June 13, 2019

**Subject: Tanja Curtis Minor Subdivision (MS-19-05)**

The Community Services Department has reviewed the Tanja Curtis Minor Subdivision development application, and has the following preliminary comments of behalf of El Paso County Parks. This application will be presented to the Park Advisory Board on July 10, 2019.

FINAL PLAT
CURTIS SUBDIVISION FILING NO. 1
 A PORTION OF THE SOUTHWEST QUARTER OF
 SECTION 21, TOWNSHIP 11 SOUTH, RANGE 66 WEST OF THE 6TH P.M.
 COUNTY OF EL PASO, STATE OF COLORADO

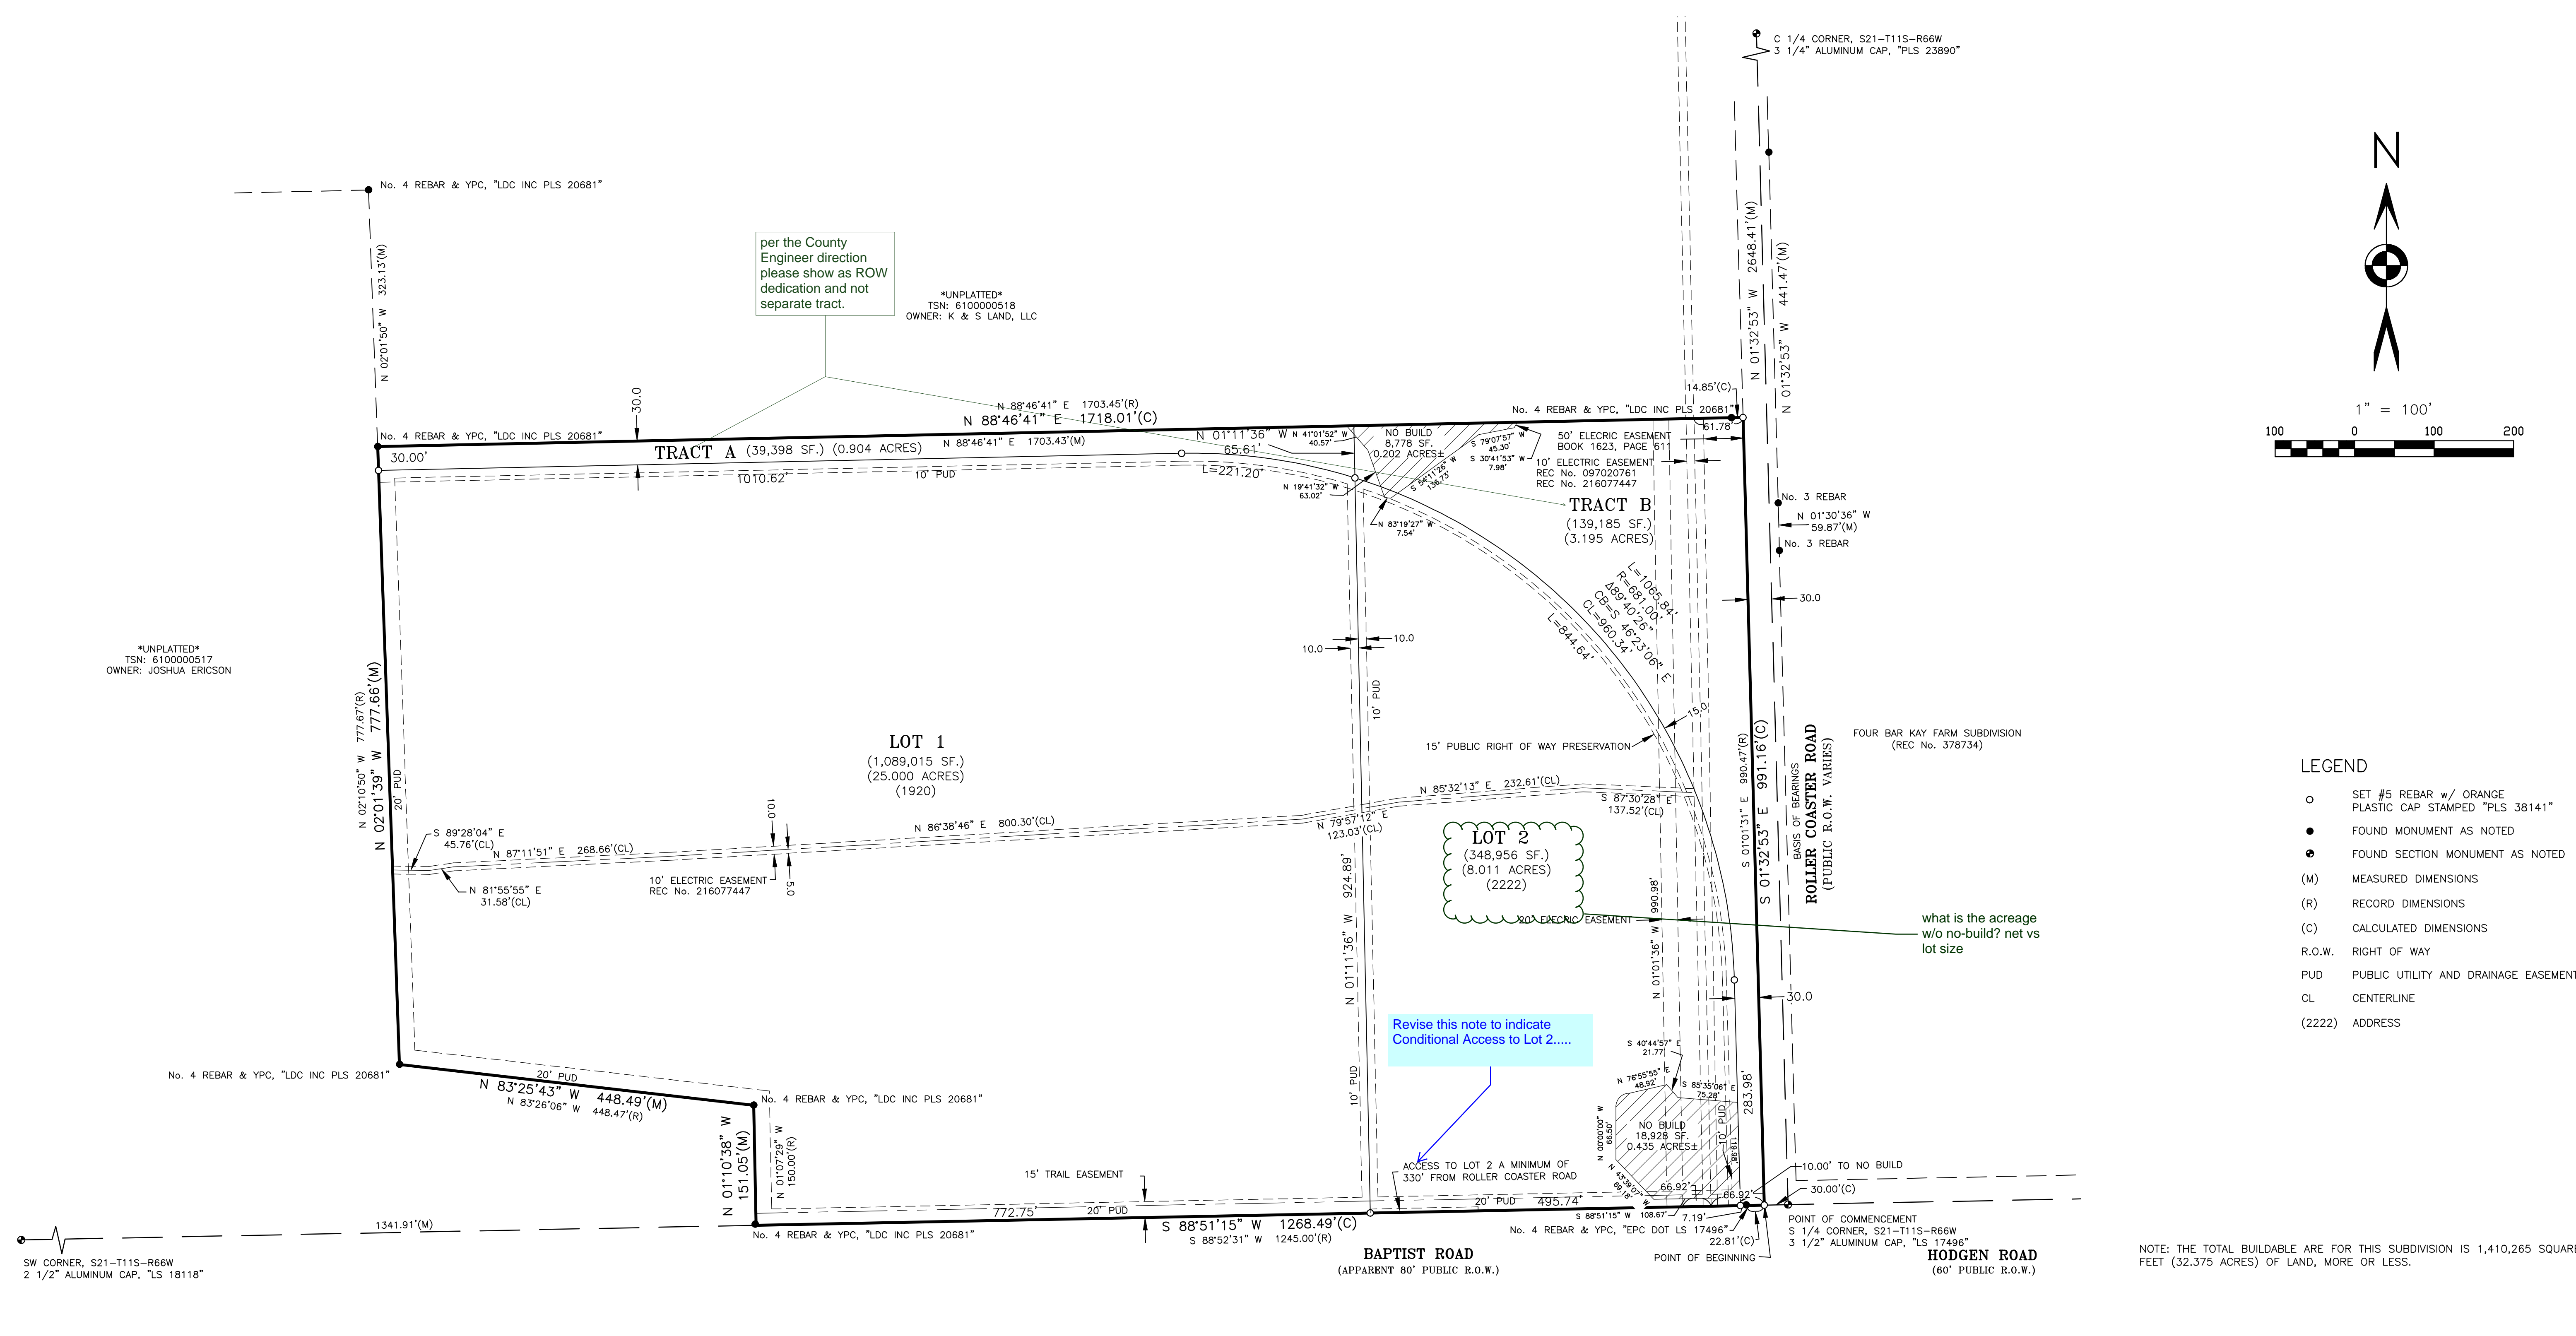
The 2013 El Paso County Parks Master Plan shows the proposed Fox Run Regional Trail and Baptist Road Route immediately adjacent to the southern boundary of the property. Dedicated right-of-way already exists along the southern boundary; however, a 25 foot wide public trail easement will be required for the Fox Run Regional Trail along the southern boundary to facilitate a connection from Hodgen Road to Fox Run Regional Park.

*Recommend to the Planning Commission and Board of County Commissioners that approval of the Tanja Curtis Minor Subdivision include the following conditions: (1) Show on the Final Plat and dedicate to El Paso County a 25-foot trail easement along the southern boundary that allows for public access, as well as construction and maintenance of the Fox Run Regional Trail; (2) require fees in lieu of land dedication for regional park purposes in the amount of \$912..*
